| CLIENT: | Whataburger | | DATE: | 2/16/2022 | | Case No: |
| PROJECT: | Whataburger NM - San Pedro and Alameda | | REFERENCE: | 2nd DRB Application Comments (via Email) | | PR2018-001346 |
| The following comments are from: Jay Rodenbeck/Jolene Wolfley/Robert Webb | | | RE: DRB - Major Case Comments | | | |

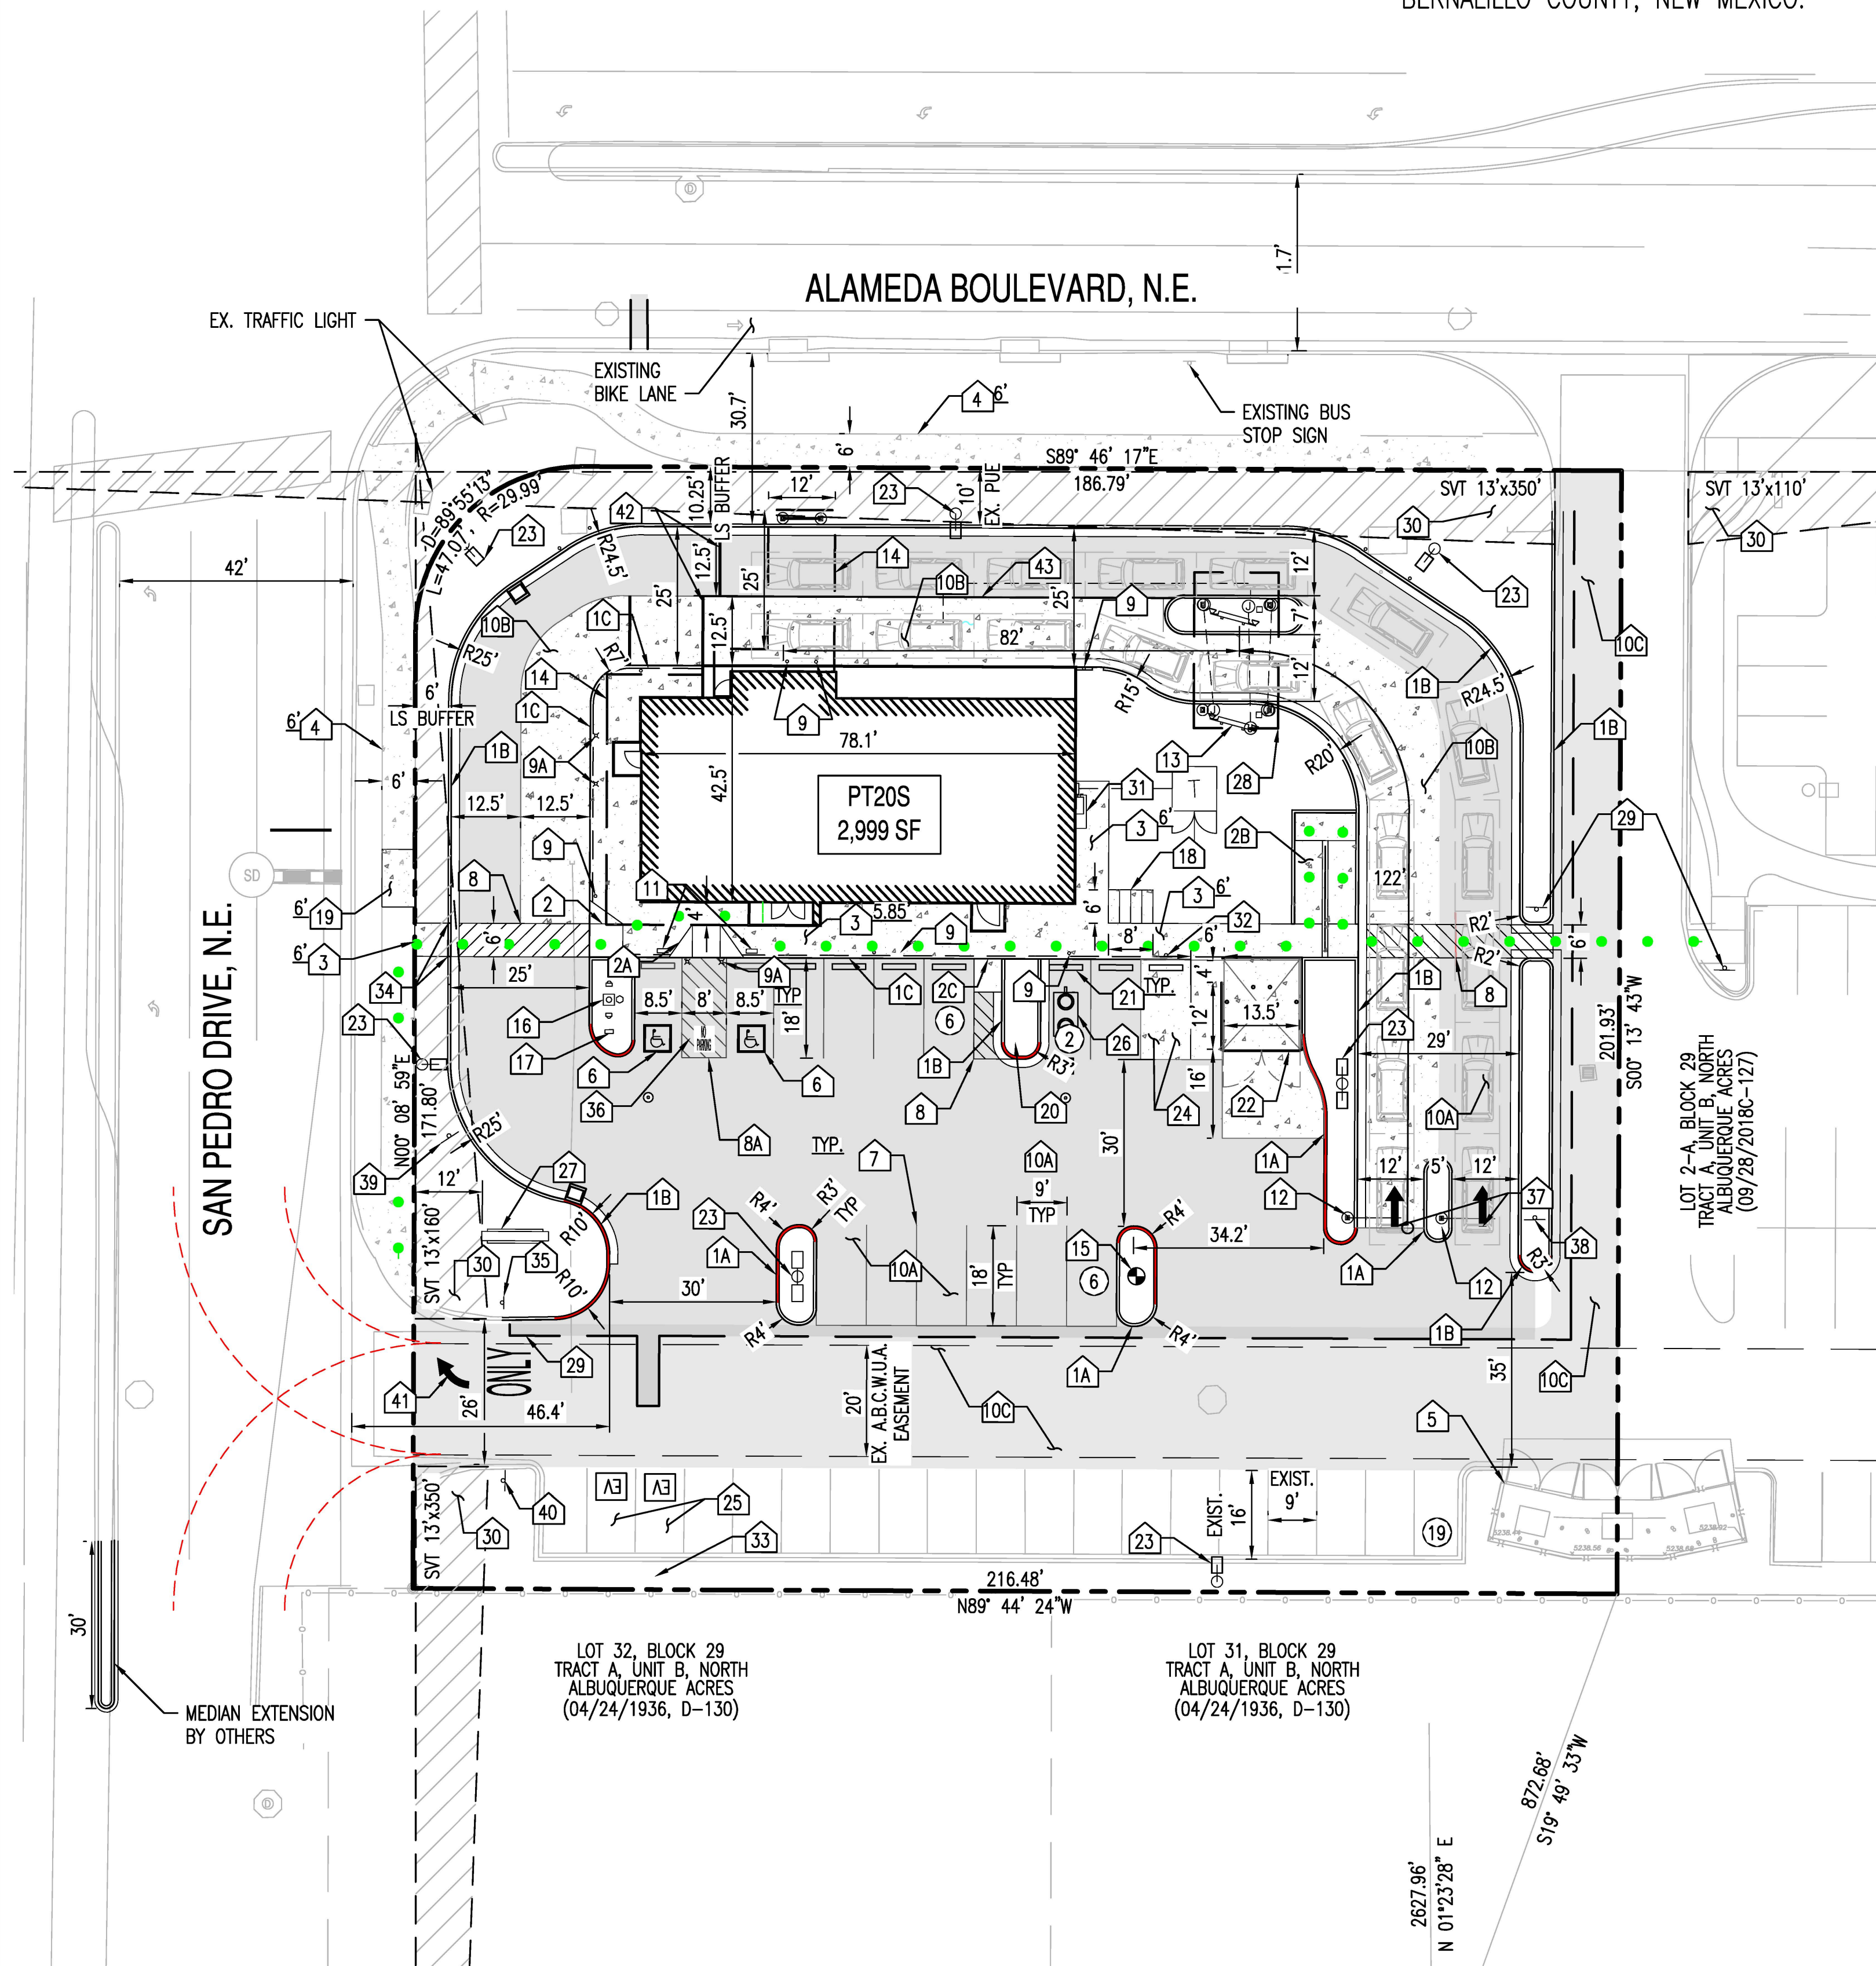
| 4 | Pg. 1 | The exit from the drive-thru is too close to the entrance off of San Pedro. Incorporate minimum throat lengths, and take into account all properties sharing the entrance. | SEG | Per email correspondence with Jeanne Wolfenbarger on 3/2/2022, we were to provide at least 2-vehicles worth of space between the exit and San Pedro curb. This has been updated in the site plan | KZ |
| 5 | Pg. 1 | The minimum pathway required to the right-of-way is 6 feet. Widen the existing 5-foot pathway to San Pedro to 6 feet wide. Revise design to avoid placing a ramp (shown graphically) on San Pedro Boulevard. | SEG | Pedestrian pathway was widened to 6'. Connection from the pathway to the public sidewalk at San Pedro Avenue is proposed without a ramp, sidewalk is flushed at ground level. | LP |
| 6 | Pg. 1 | Provide rounded curb, curb radii, and a pedestrian width at Keyed Note 29. | SEG | Rounded curbs with 2' radiuses were incorporated in the plan. Pathway width was added as well. | LP |

| 7 | Pg. 1 | List parking space lengths and widths for all parking lot segments. Follow minimum DPM requirements. If compact spaces are being provided, there is a limit to how many can be provided, and they must be marked as "Compact" in the back of the parking space. | SEG | Parking spaces lengths and widths are shown as typical dimensions, except for the ADA spaces which are called out separately. No compact spaces are proposed. | LP |
| 8 | Pg. 1 | On the drive-thru aisle, a minimum radius of 15 feet shall be used for the interior radius. Also list all curb radii on-site (including islands), and use keyed notes to specify a 6" – 8" curb height. For the exit from the site to the existing drive aisle, if trucks are utilizing this exit, a 25-foot radius should be used. | SEG | required for typical dt width at 12' this site not typical and has 25' wide dt lane allowing for manuevaerability | |
| 10 | Pg. 1 | For the one-way aisle, place "One Way" signage and directional arrows. Place "Do Not Enter" signage at the egress. | SEG | A "One-way" signage was added at the drive-thru ingress, similarly a "Do not Enter" signage was added to the drive-thru egress. All per COA standard details. | LP |
| 11 | Pg. 1 | Show bicycle parking on the plan; call out overall dimensions for this bicycle parking area. | SEG | Bicycle parking shown with keynote no. 18, dimensions were added accordingly. | LP |
| 13 | Pg. 2 | Use intersection sight distance triangles for the accessways off of San Pedro and Alameda Boulevard per the DPM guidelines. Add the following note as well: " Landscaping, fencing and signing will not interfere with clear sight requirements. Therefore, signs, walls, trees, and shrubbery between 3 and 8 feet tall (as measured from the gutter pan) will not be acceptable in the clear sight triangle. " (These shall be shown on the landscaping plan, too.) Sight distance triangles should not be shown to go through any structures such as fencing that cannot be seen through. | SEG | Sight triangles were added to driveways connecting to San Pedro Avenue and Alameda Boulevard, all 11' X 11' per DPM. Sight distance note was added to the plan. | LP |

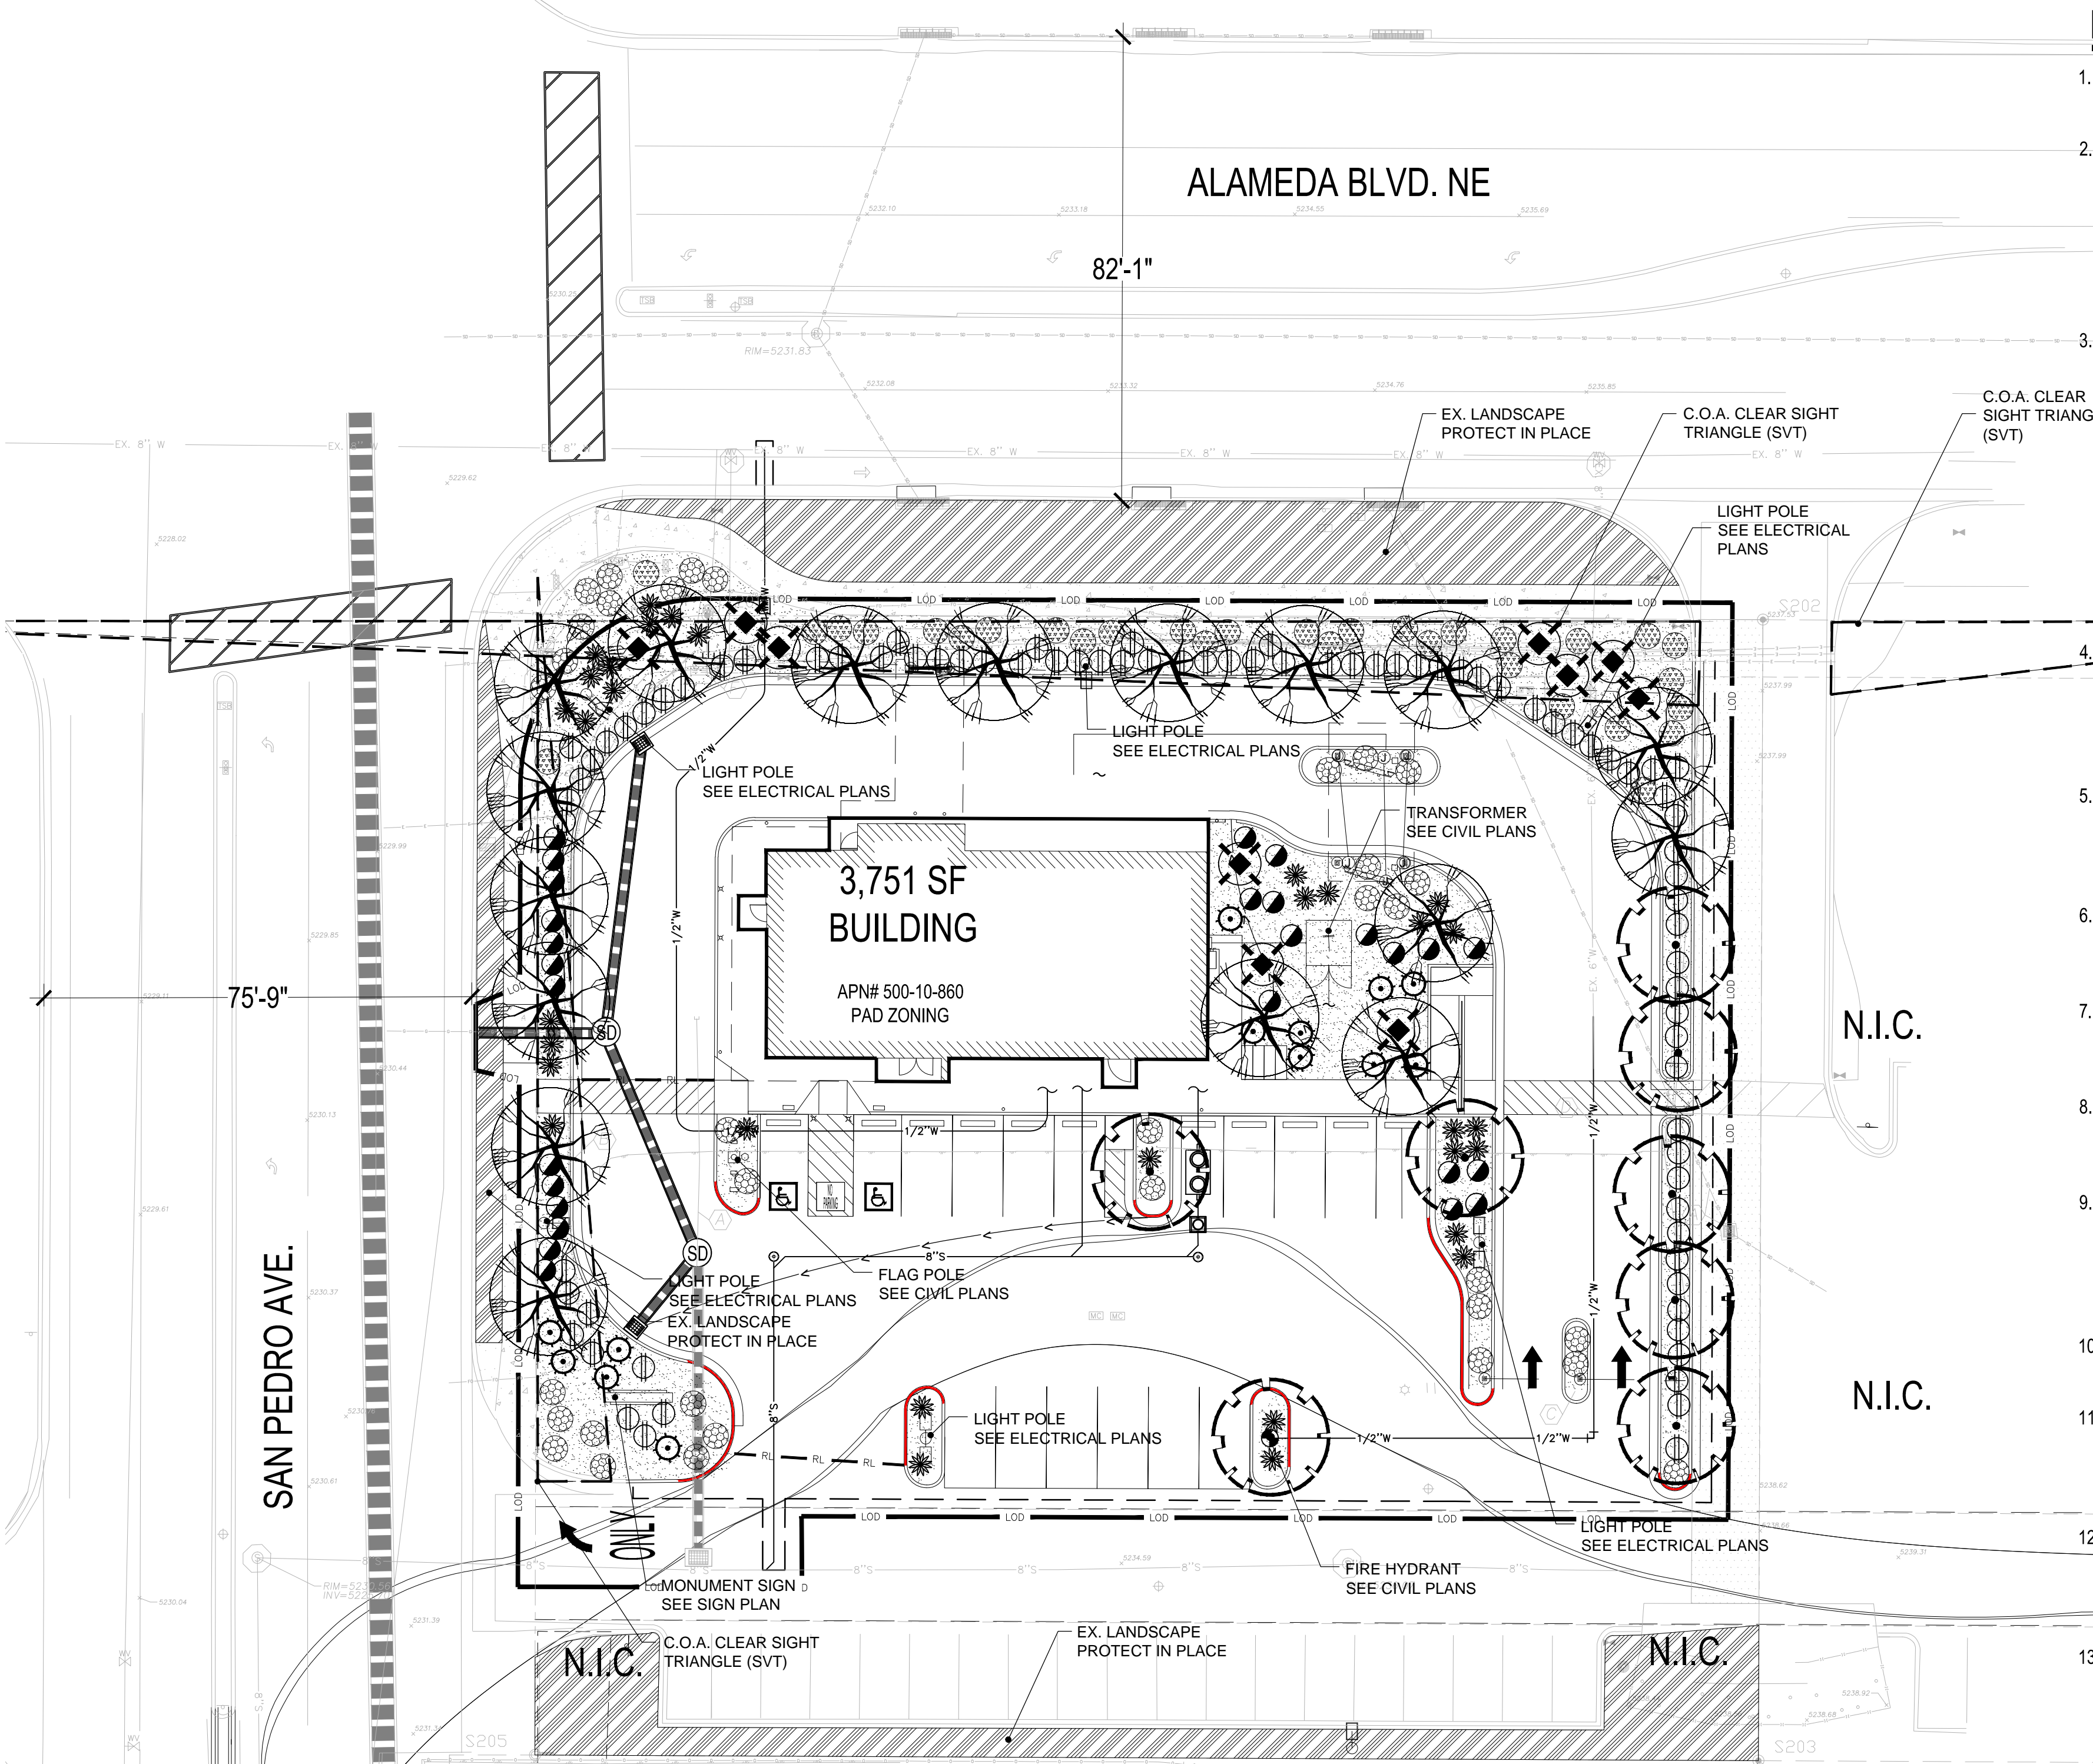
| No. | Plan Sheet No. | COMMENT | Responsible Company | RESPONSE | Response by: (PM/Designer) |
|---|----------------|--|--|---|----------------------------|
| 2 | 1 | ID IDO section 5-5-(l)(2) indicates the Drive-Through lanes adjacent to Public ROW are required to have a Vegetative Screen or Wall. Landscape plan shows ground cover plants rather than shrubs in that area of the LS plan on L.1.1, and no wall is evident. | SEG | Understory plants replaced with evergreen shrub between evergreen trees to screen visible direction of menu signs. Yellow Bird of Paradise utilized. | KZ |

| 3 | 1 | IDO section 5-11 (E) street-facing Façade requirements for North and West sides. Appears deficient on North street-facing façade. Please justify how these requirements are being met. | SEG | Added full awning over the pick-up window creating an arcade over the DT lane further creating sun shade for DT vehicles. Other supplemental canopy includes an orange canopy that wraps around the north west building corner and provides an exterior feature to break apart the horizontal facade. At the Pick-up window the brick was fully raised creating a break in the roofline canopy and indulation along the horizontal facades. See updated elevations | KZ |
|----------------------------------|----------------|---|--|--|----------------------------|
| 1 | Pg. 1 | Per IDO 5-6(D), street trees required 20-ft from curb and approximately 25-ft on center. Albuquerque is currently USDA hardiness zone 7. Some species listed on the Landscape Plan have hardiness zones higher/warmer than what currently exists in Albuquerque and should be exchanged. IDO Section 5-6(D)(1)(b) requires tree species to be recommended on the Official Albuquerque Plant Palette (linked here: Official Albuquerque Plant Palette and Sizing List-2018-07-03.xlsx (cabq.gov)). And the Nature Conservancy has a Climate Ready list (linked here: NM_ClimateReadyTrees.pdf (nature.org)). The Parks and Recreation Department prefers species cross-referenced. (Please contact me at csomerfeldt@cabq.gov with any questions). | HPD | Trees revised to use Escarpment Oak and Chaste Tree (approved materials from tree list). | KZ |
